Harnett County Government Complex
307 W. Cornelius Harnett Boulevard
Lillington, NC 27546

Re: Status of Improvement Permit Application #17-5-41651

An attempt was made to evaluate your property for the purpose of issuing an Improvement Permit. The evaluation could not be completed for one or more of the following reasons.

474 AVERY POND DR. FUQUAY-VARINA NC 27526
PROPOSED PLOT PLAN LOT 51
AVERY POND S/D PHASE II
 TOWNSHIP: HECTORS CREEK COUNTY: HARNETT STATE: NORTH CAROLINA DATE: MAY 19, 2017

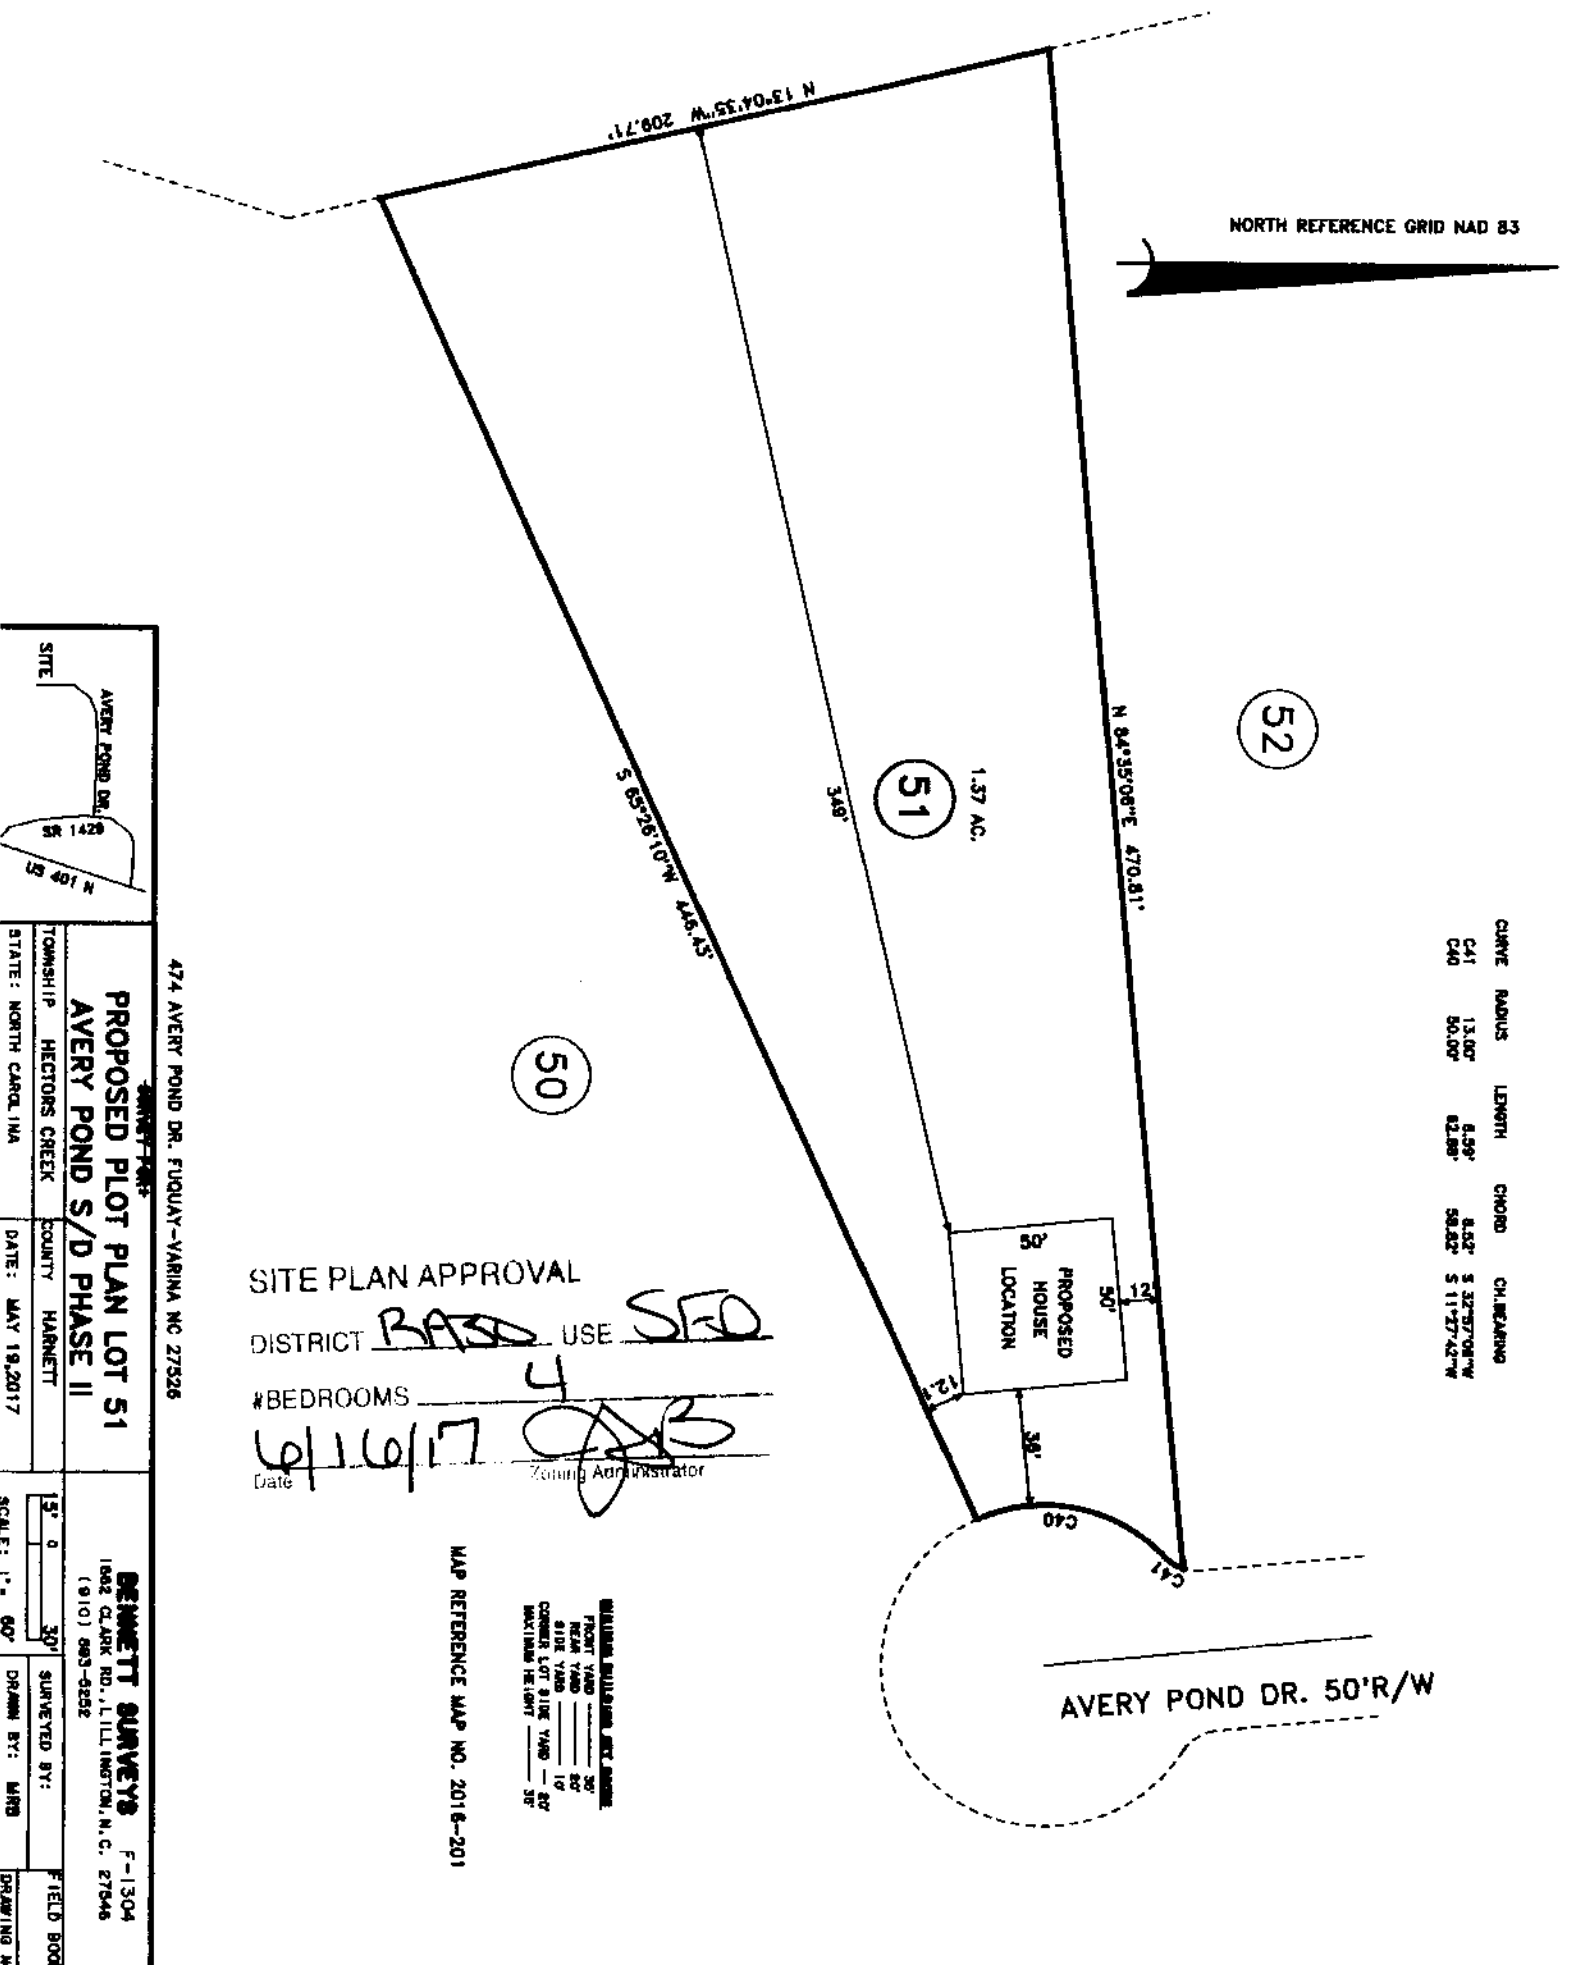
- 1. Use pink flags to mark property lines and irons that are set by surveyor need to be visible *(\$25.00 fee incurred)*
- 2. Use orange flags to mark house corners *(\$25.00 fee incurred)*
- 3. Directions not clear to property *(\$25.00 fee incurred)*
- 4. Property needs only brush or vegetation removed
- 5. Driveway not shown on site plan – Please revise site plan to include.
- 6. Backhoe pits required
- 7. Other
